# CITY OF ALBUQUERQUE

**RE: La Vista Subdivision - Lot 17, Block 1, NAA Tracts 2, Unit 3  
Grading and Drainage Plan  
Engineer's Stamp Date 10-2-15 (File: C19D042A)**

Drawing file: LA Vista Subd / LA VISTA LOT 17 G&D 8-28-14.pdf

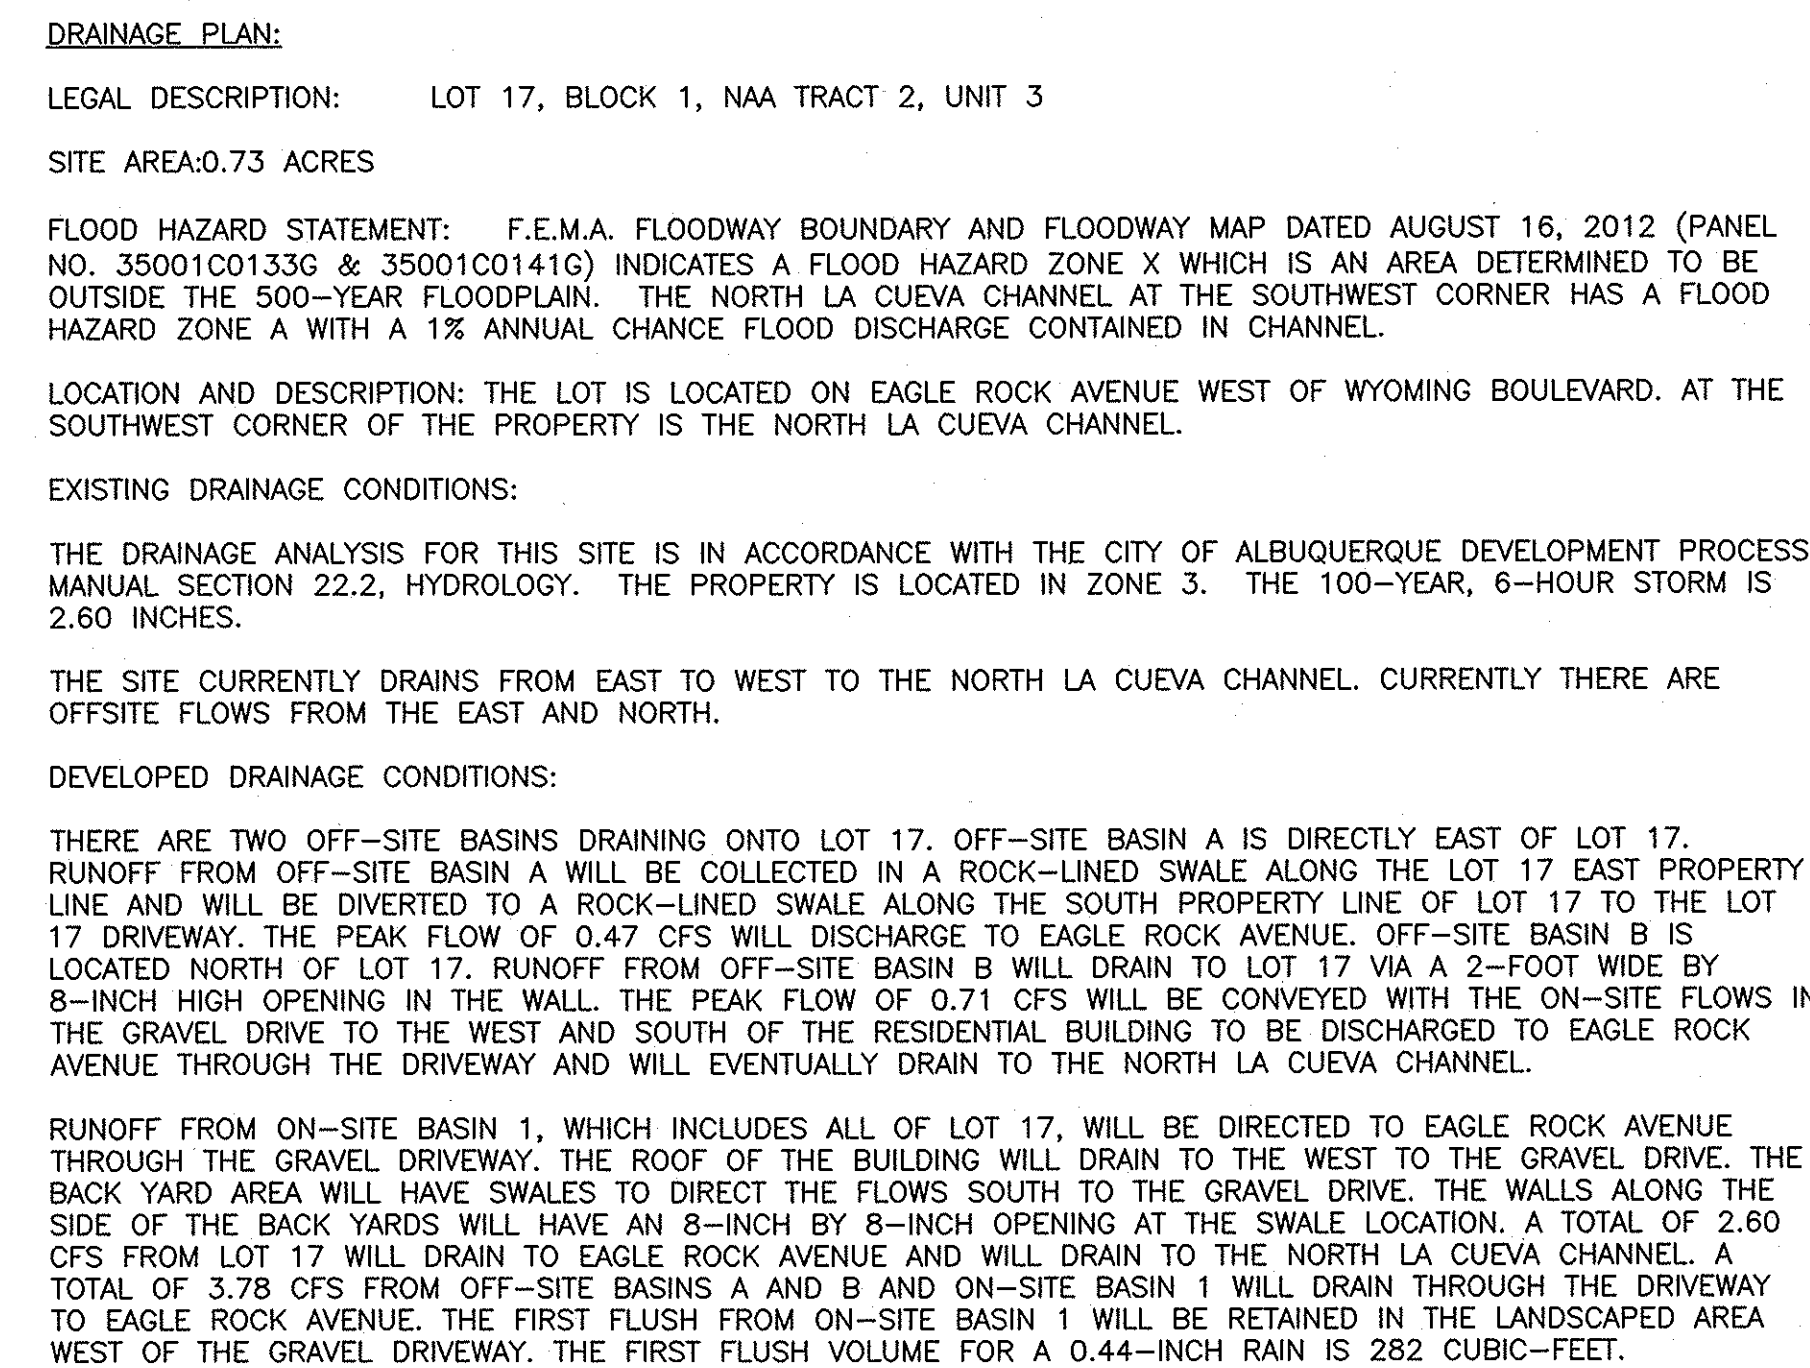
1. Show how the proposed grades around the perimeter of the lot will tie to existing ground.
  - a. East Perimeter: Basin A should be graded to drain to the swale; it appears that the east edge of the swale will be higher than existing ground.

- b. South Perimeter: Show elevations of the sidewalk that are consistent with the future vertical alignment of the Eagle Rock sidewalk (Sheet 2 shows that the future sidewalk ties to the proposed interim sidewalk).

- c. Driveway: The spot elevations of the driveway don't match the roadway elevations.
  - d. West Perimeter: Provide a section along the retaining wall to clarify the intent to provide positive drainage away from the wall, or if any fill is needed.

2. Ensure that the NE wall opening is aligned with the low spot, which appears to be at the corner of the Lot 6 & Lot 17 lot line intersection; or show grading that conveys flows to that point. Coordinate the possible need for an easement since the site will be accepting flows from the Wyoming Blvd Right of Way.

3. Provide a roadway edge (curbing or wall) along the west edge of the access easement between the retaining wall and the driveway.

4. The drivepad should have flared corners to prevent potholing at the 90-degree corner with the edge of pavement. It is understood that the improvements on Eagle Rock will develop this driveway; compacted base course can be used to protect the corners in the interim condition.
5. Provide a continuous sidewalk connection across the rock-lined swale (a sidewalk culvert or driveway culvert might be needed).
